Application Amendments

Application H13/0929/02 **2**

Location Plot 1, Off The Sidings
Moulton

Amendment: Frontage wall removed and just consider side wall
(dwg. no.1135/05/01B_

FRONT WALL DETAIL

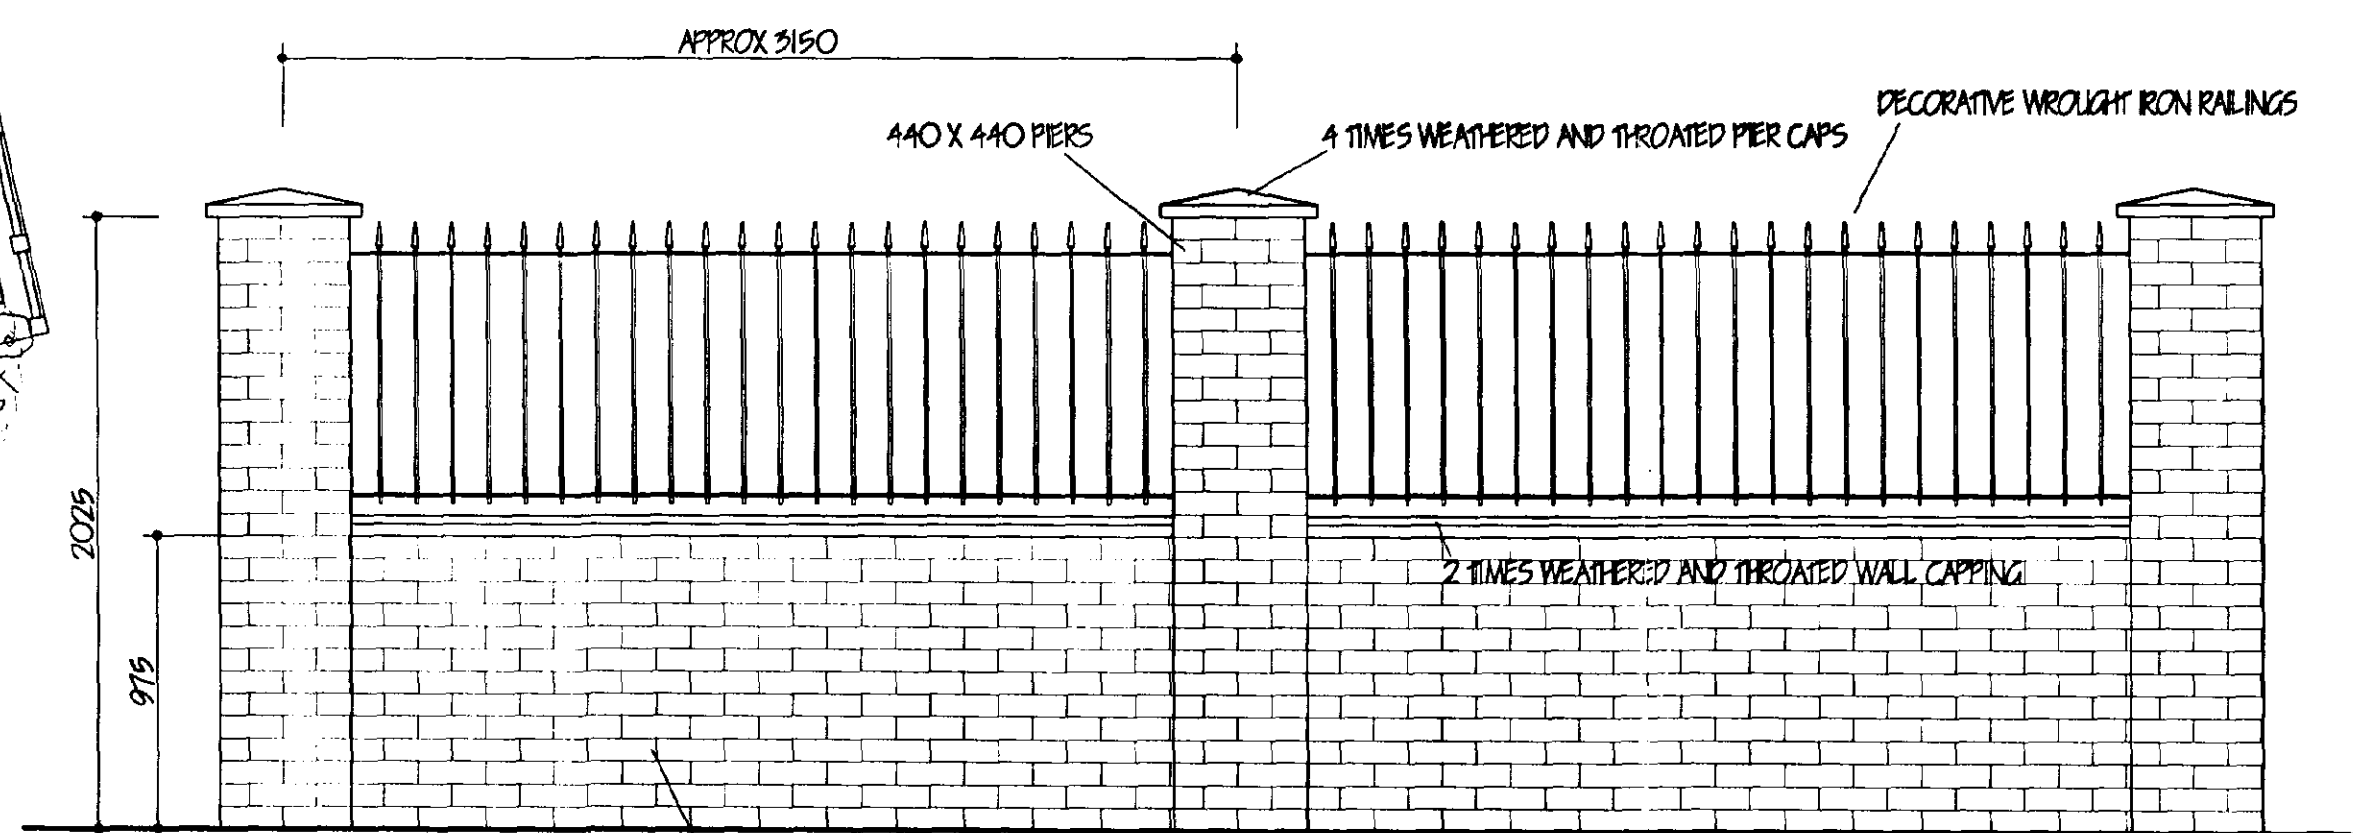
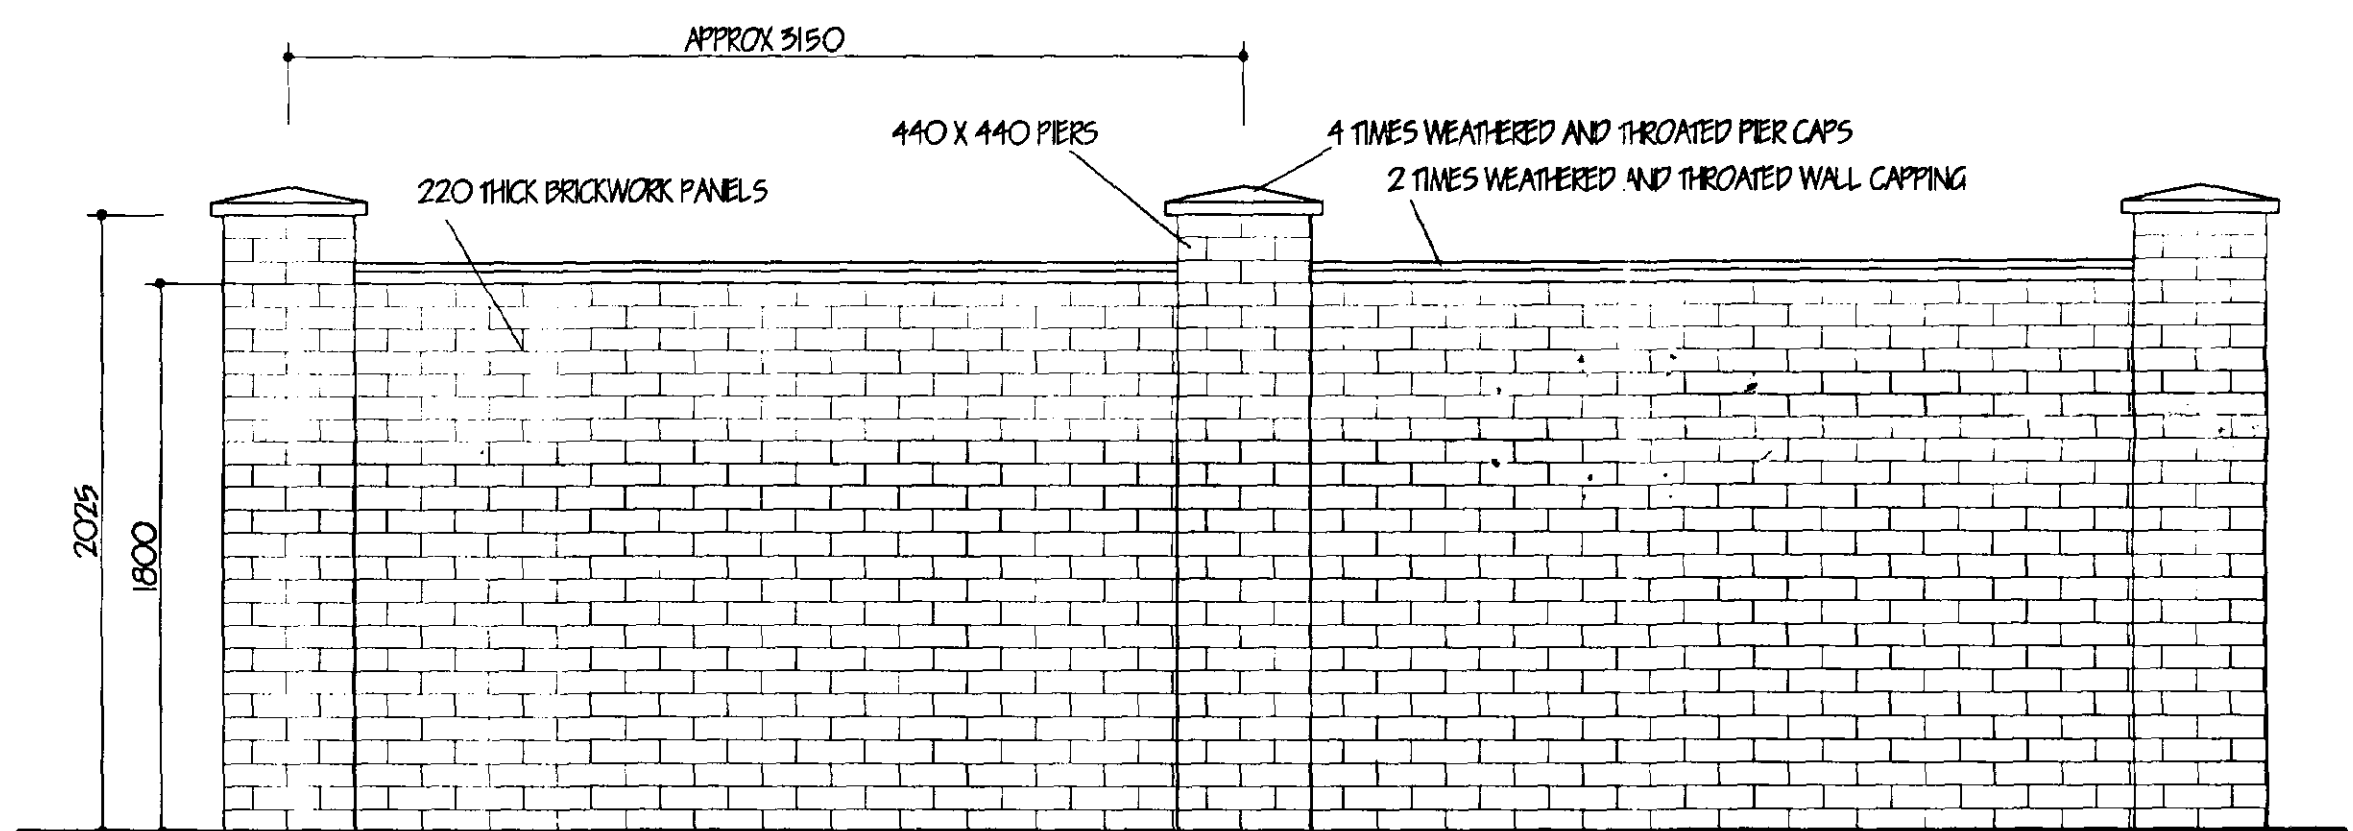
Front wall removed
Just consider side wall

The amended details submitted in respect of the above proposal have now been considered and there are no objections to the amendment being implemented to the extent described above.

Drawing
 PLOT 1
 BLOCK AND
 LOCATION PLANS

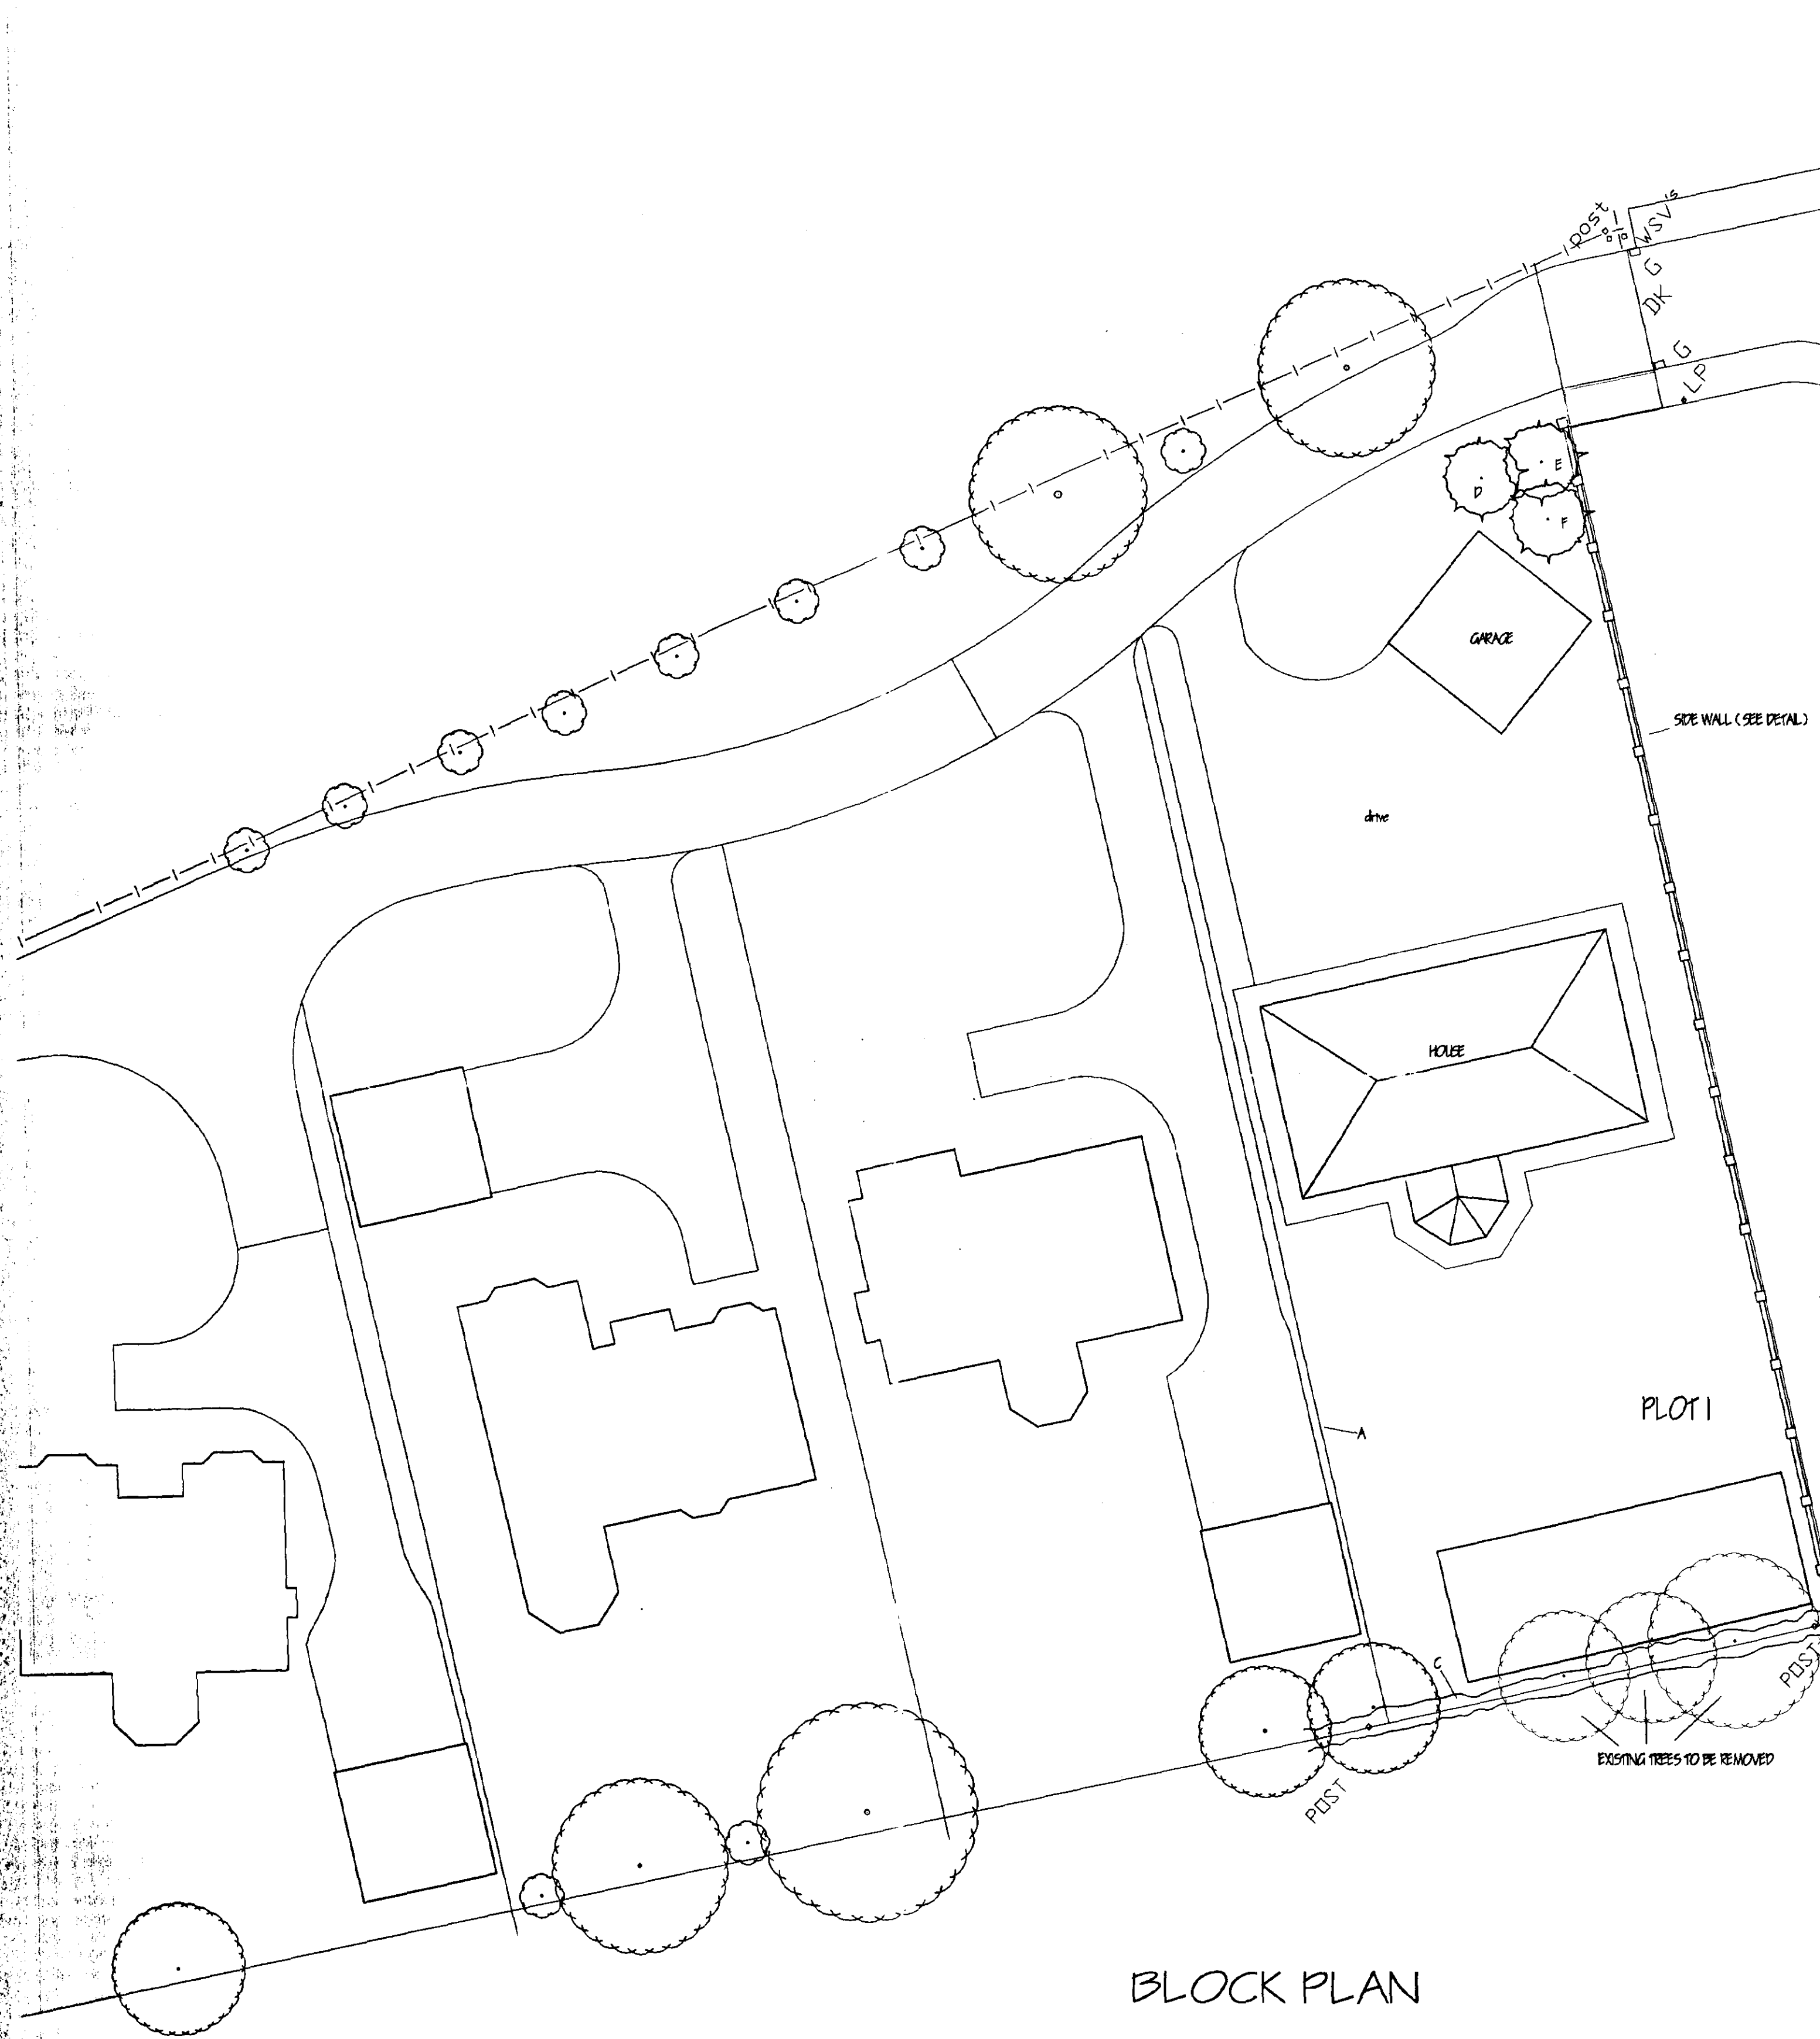
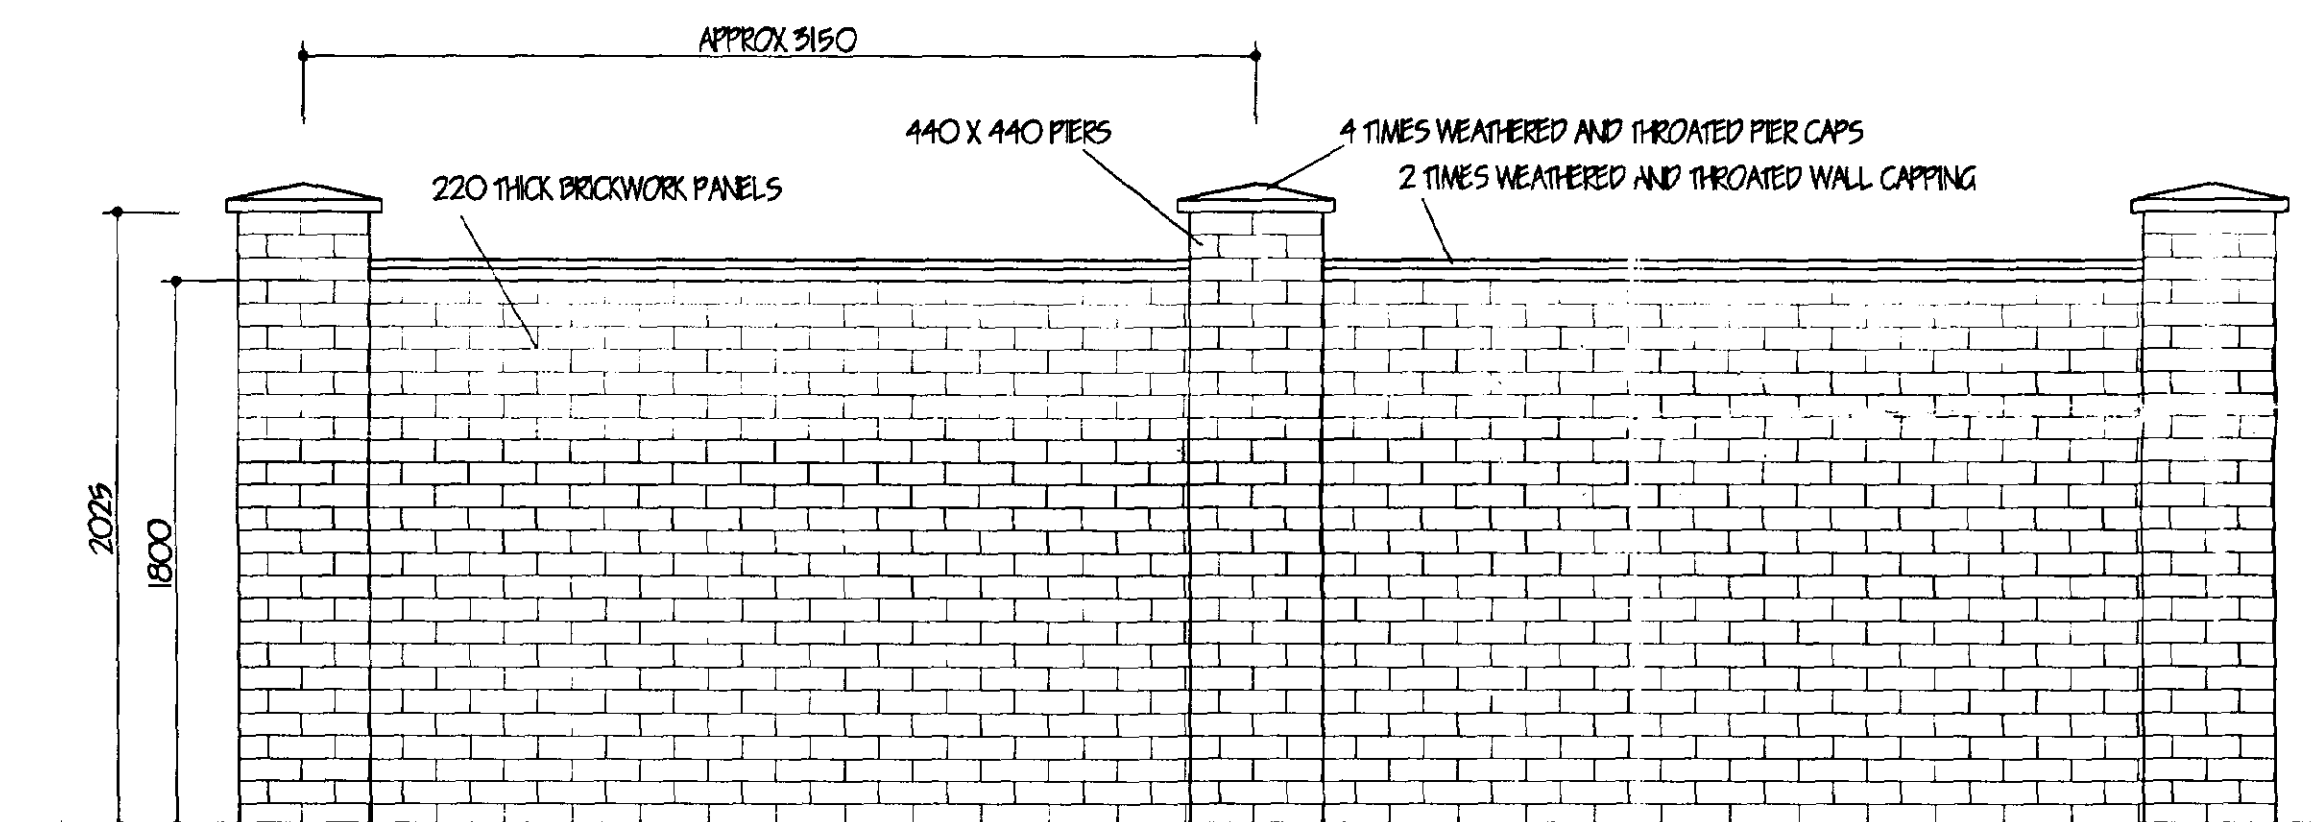
Description ☒ Frontage wall removed. Just consider side wall.
☒ Dwg. no. 01B
